WEST SUSSEX COUNTY COUNCIL CONSULTATION

TO:	Arun District Council FAO: Simon Davis
FROM:	WSCC - Highways Authority
DATE:	1 March 2022
LOCATION:	Land West of Bilsham Road Yapton
SUBJECT:	Y/3/22/OUT Hybrid Application comprising of: Outline planning application for further phases of up to 110 No dwellings and associated infrastructure (with all matters reserved) and Full application for Phase 1 for 30 No residential dwellings, new access from Bilsham Road, public open space, landscaping, sustainable urban drainage and associated works. This application is a Departure from the Development Plan and is in CIL Zone and is CIL Liable as new dwellings.
DATE OF SITE VISIT:	n/a
RECOMMENDATION:	More Information
S106 CONTRIBUTION TOTAL:	n/a

KEY
SITE BOUNDARY
2.4m X 59m VISIBILITY PLAYS BASED UPON APPROVED ACCESS DRAWING FOR LAND TO NORTH OF SITE (APP NO: Y91217001) SPEED SURVEY FROM THIS APPLICATION SHOW 85TH SPEEDS OF c.35-36mph

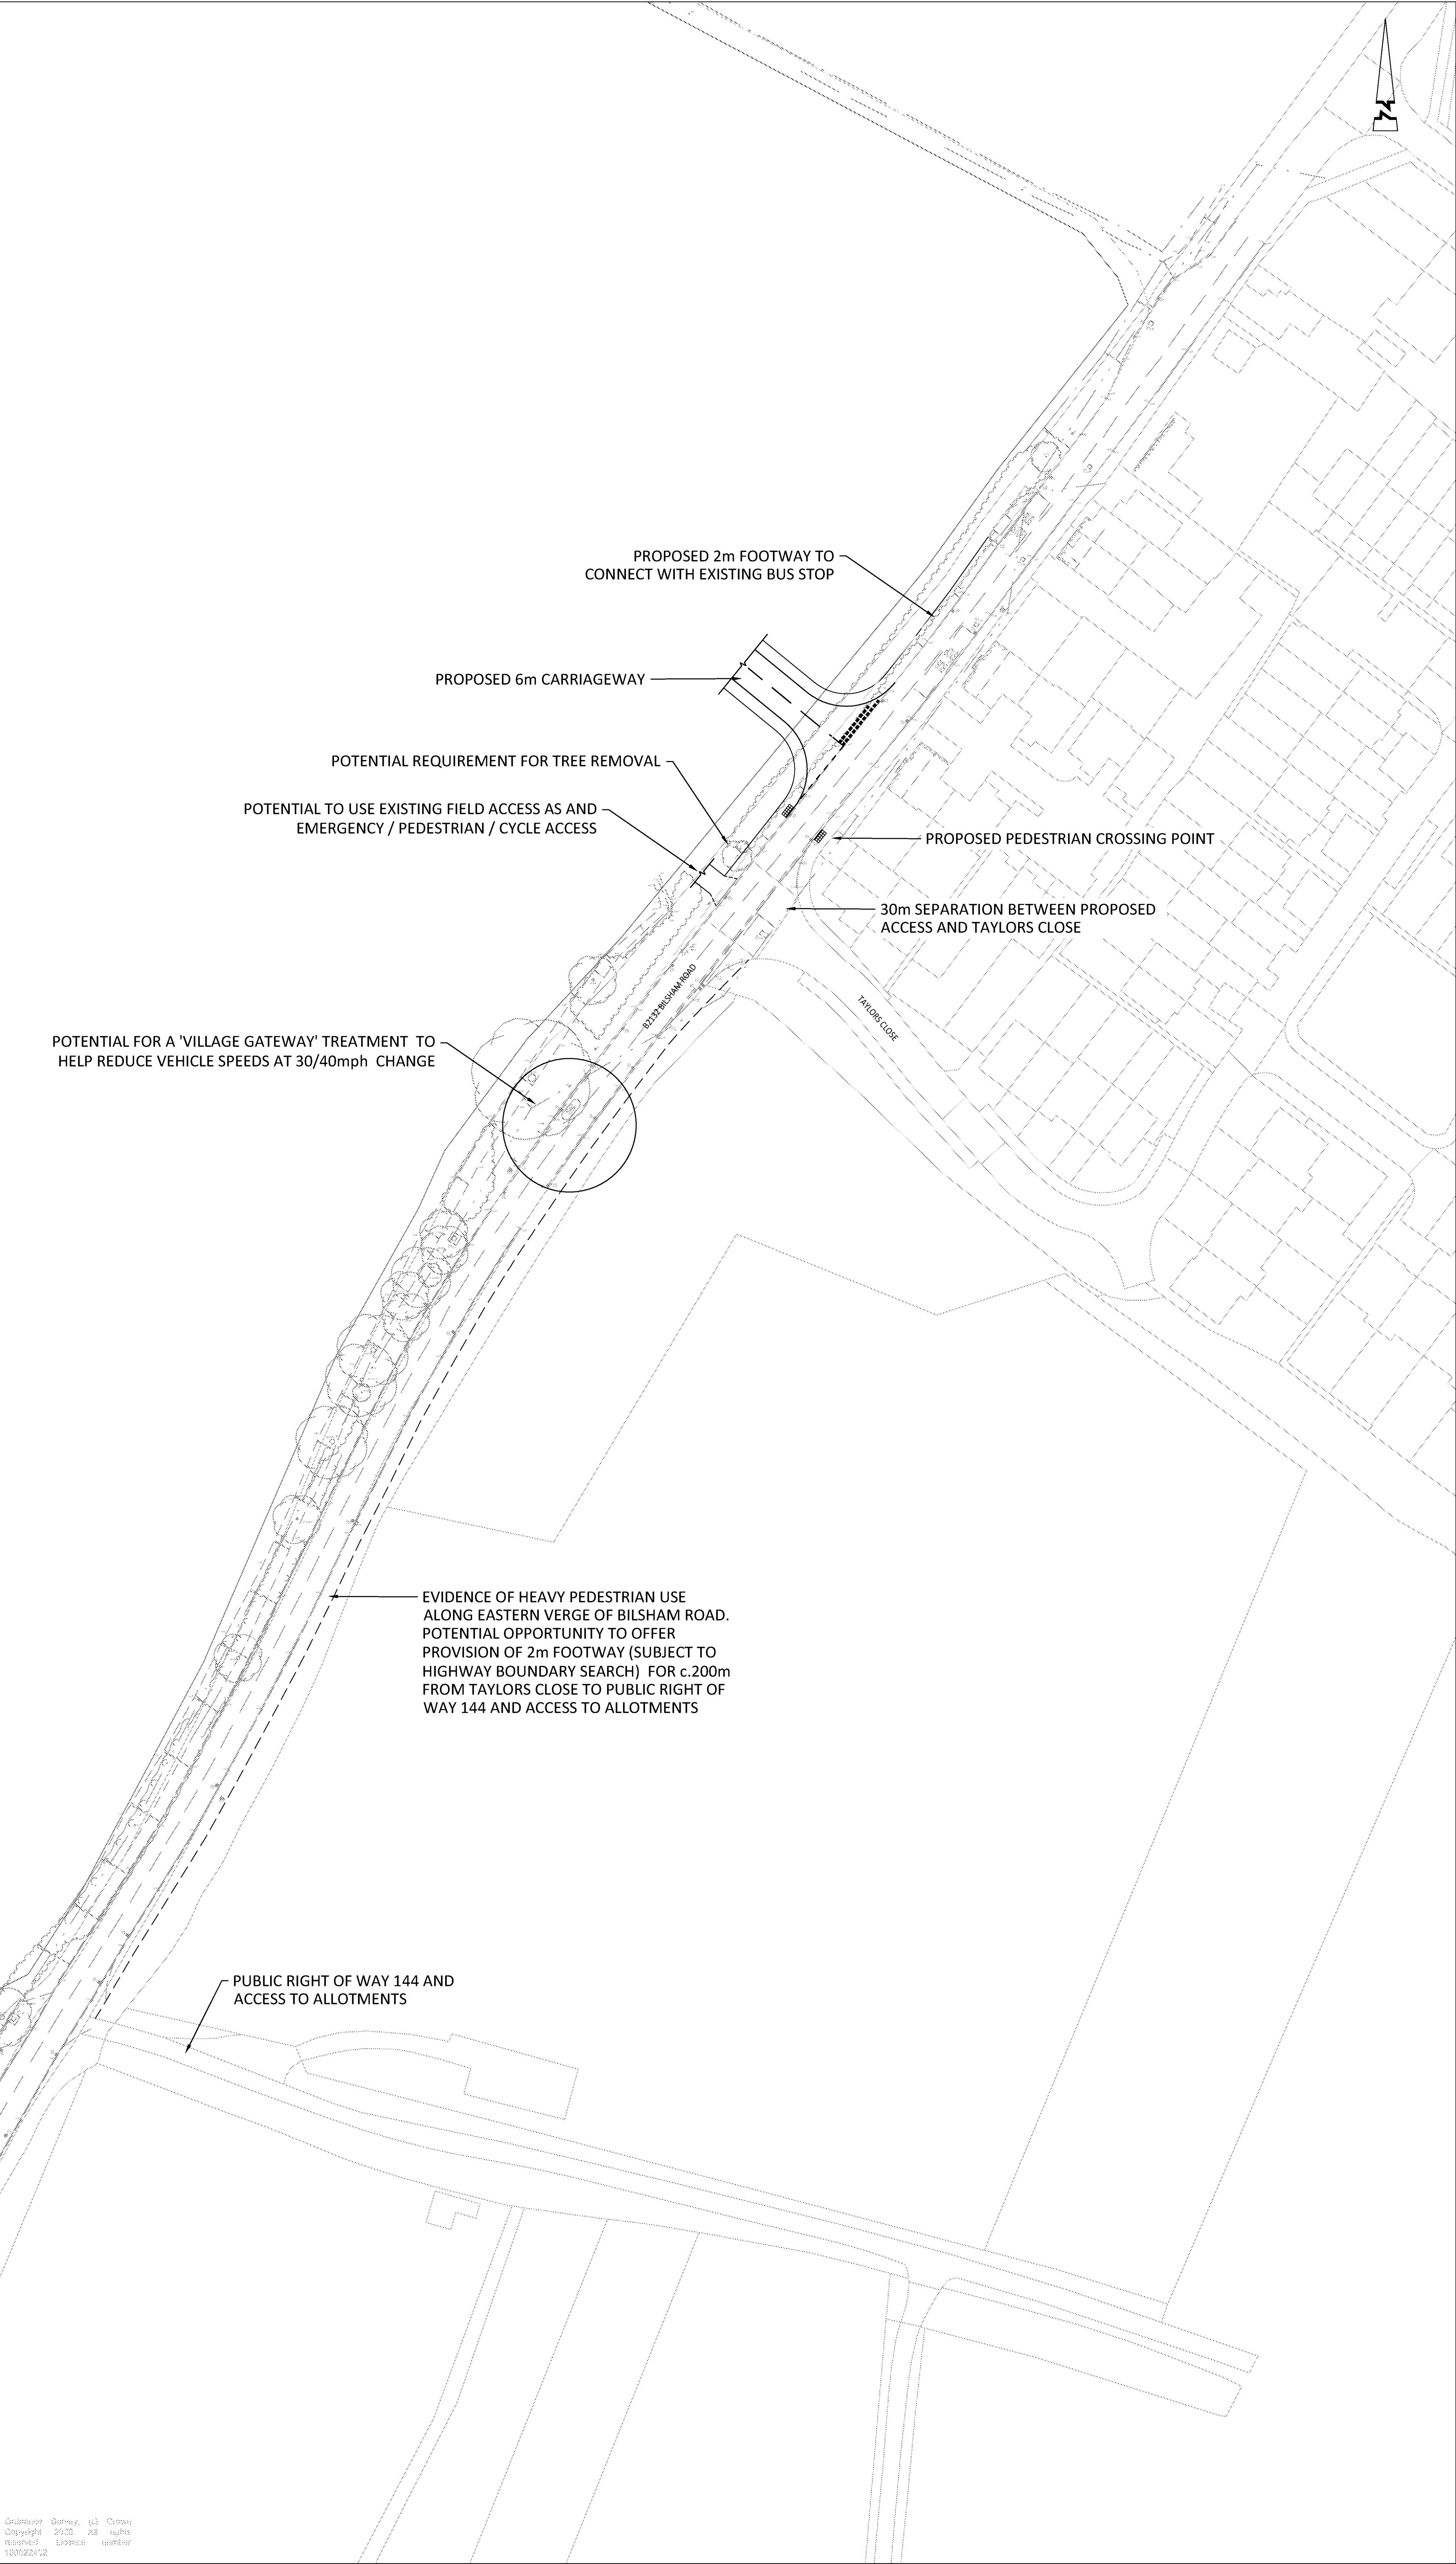
The TA states that visibility splays of 2.4 metres x 73 metres can be achieved in both directions, these would be in line with the recorded 85th percentile road speeds of 38 mph in both directions. Having assessed the methodology provided within the TA we would accept that the recorded speeds are in line with Manual for Streets 2 (MfS2) parameters for this road and the local context. From inspection of the TA, there does not appear to be a drawing which provides the details showing the 73 metre splays as outlined in Section 4.7 of the TA, this should be provided for clarity.

- Visibility splay plan showing achievable 2.4 by 73 metre splays
- RSAAR for the LHA to sign off
- Revised junction modelling as outlined in the Capacity Section of this report
- Confirmation of the likely contribution that the applicant is willing to consider for the Comet Corner improvements.
